# Technical Memorandum

Date: 7 September 2017  
Project: 908157-03000

**Re: Southminster Church – 1040 Bank Street  
Residential Development – Parking Review**

Figure 1: Existing On-Site and On-Street Parking

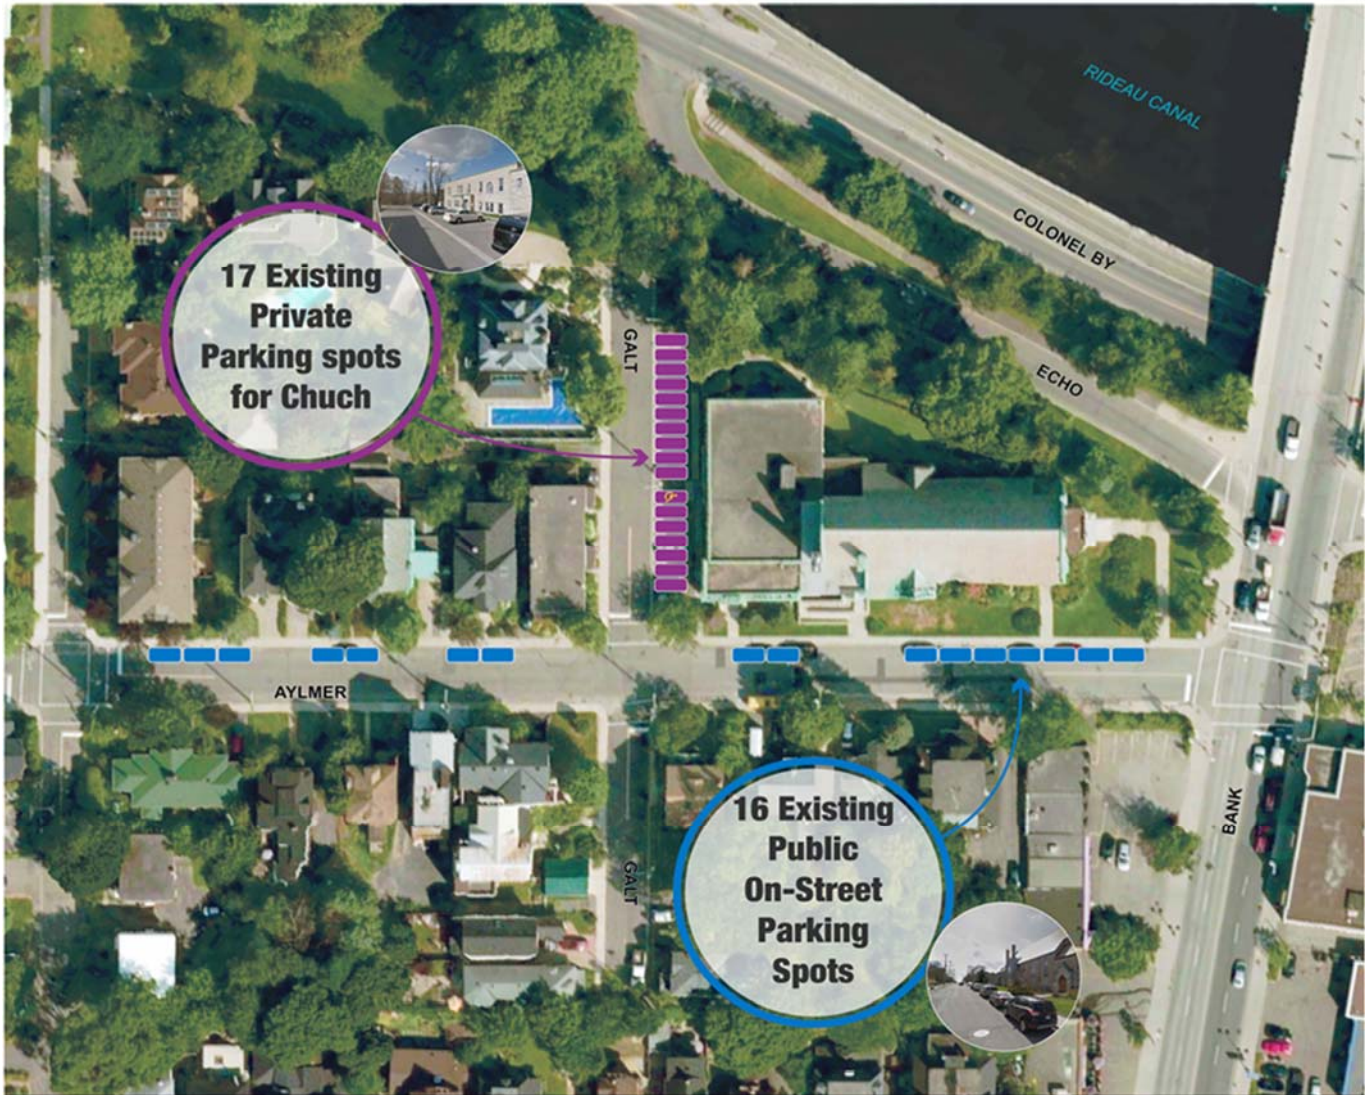
**Comment 12:** Please provide a parking study prepared by a qualified professional assessing supply and demand for on-street parking within the surrounding neighbourhood (approximately 400 metres).

**Response 12:** Based on a preliminary assessment of the area, within a 450 m walking distance from the site, there are approximately 121 existing on-street parking spaces. This is outlined in Table 1 below. The 17 private parking spaces on the subject site are not included in this count.
